**ADC PARKS & GREENSPACE ARBORICULTURE**

**PLANNING APPLICATION:** AL/73/14/PL

**ADDRESS:** Land adjoining Sunnyside Westergate Street Westergate PO20 3QR

**BRIEF DESCRIPTION:** Erection of 2 No three bedroom semi-detached dwellings (Plots 1a & 1b) together with new boundary treatment & landscaping & extension of access road to serve site (Part alternative to AL/114/12). This application affects a public right of way.

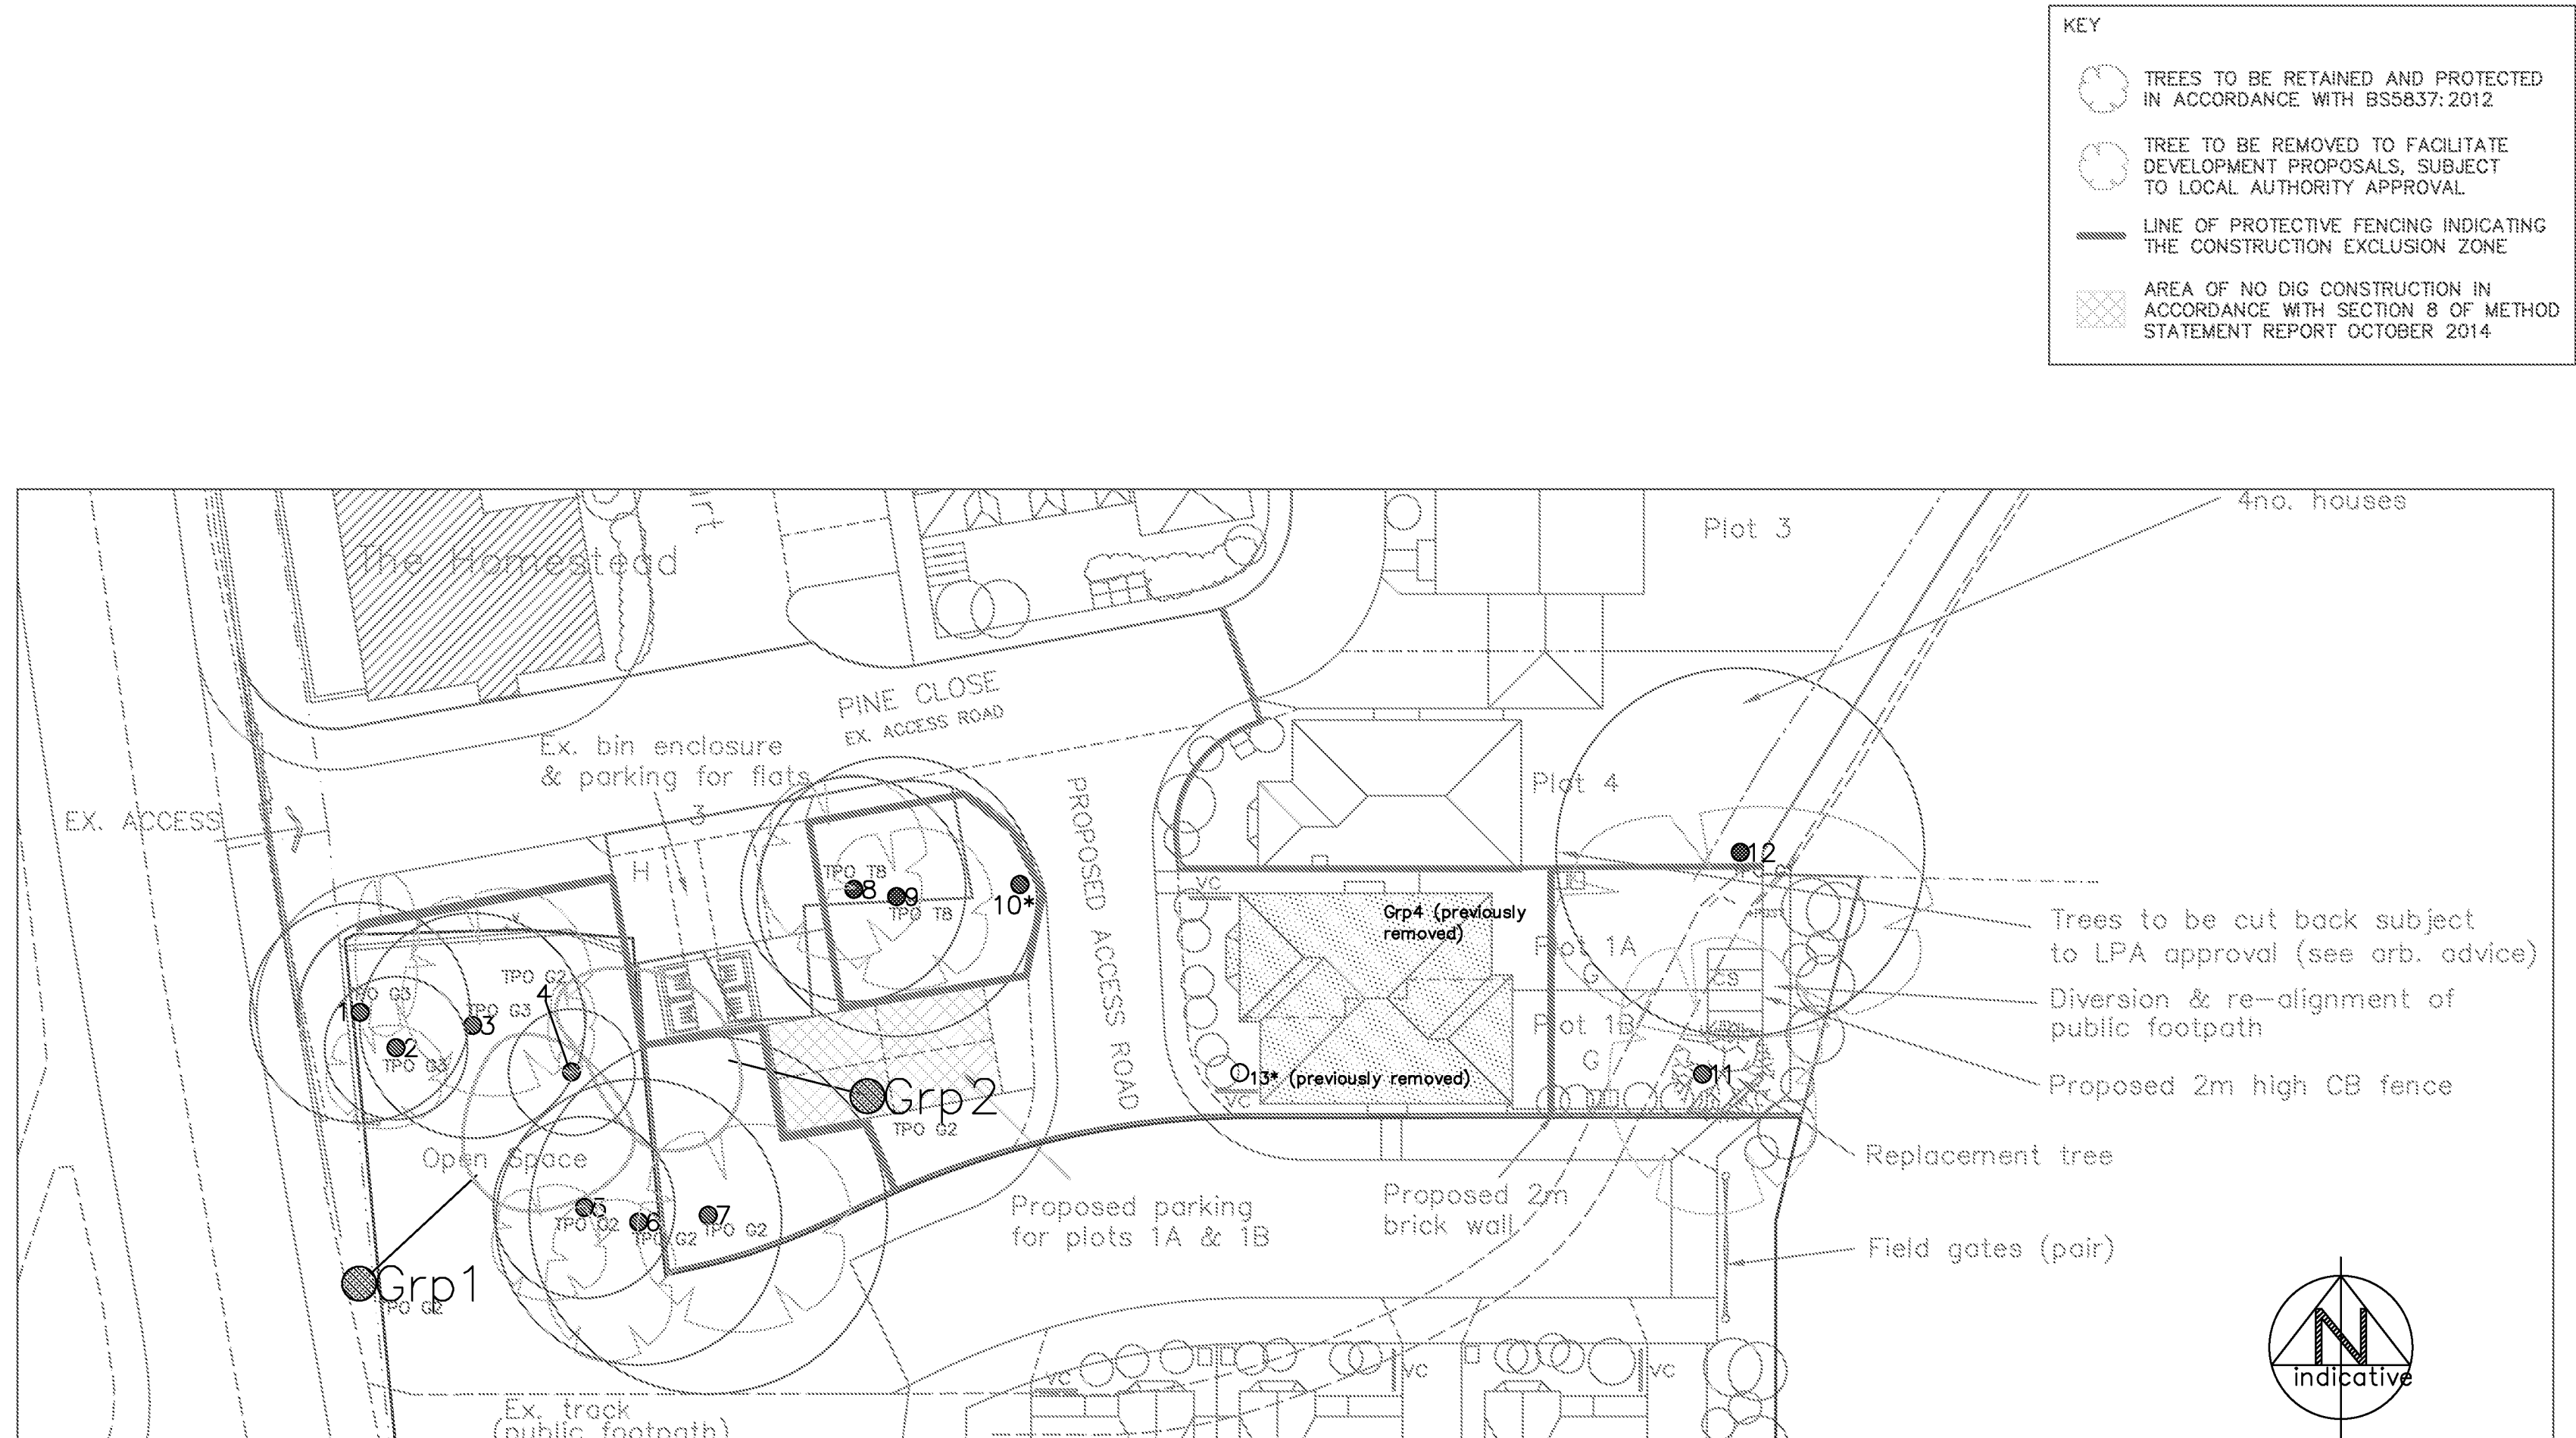
- The applicant has supplied relevant information of the proposed mitigation, in the form of BS5837 fencing for trees 1 to 6,8,12, group 1 and group 2. All this provided data would conform to the BS5837 standard.

- As for trees 7 and 9, there is a conflict between the proposed construction operation and the protection that is required. T7 and T9 would see an encroachment of their relative RPAs for parking areas. Section 8.5.1 of the application has indicated the use of no-dig surfaces which will be installed in areas of the Root Protection Areas. The application has also stated that once completed no more that 20% of the RPA should be covered by a non-porous surface.

- As for T10 the report has indicated this individual should be removed as T10 is a stump that has some suckering that is keeping it alive. (this 'stump' has low aesthetic value and is not much of the feature on the landscape).

- The removal of T11 has already been approved as part of a previous application AL/114/12.

- **I would therefore have no objection to the mitigation/protection that is being offered by the submitted application for T1- T10, T12, Group 1 and group 2 as it meets the criteria as stipulated in the BS 5837.**
- **As the removal of T11 has been granted previously under AL/114/12, I would have no objection to the felling of this outlined tree.**
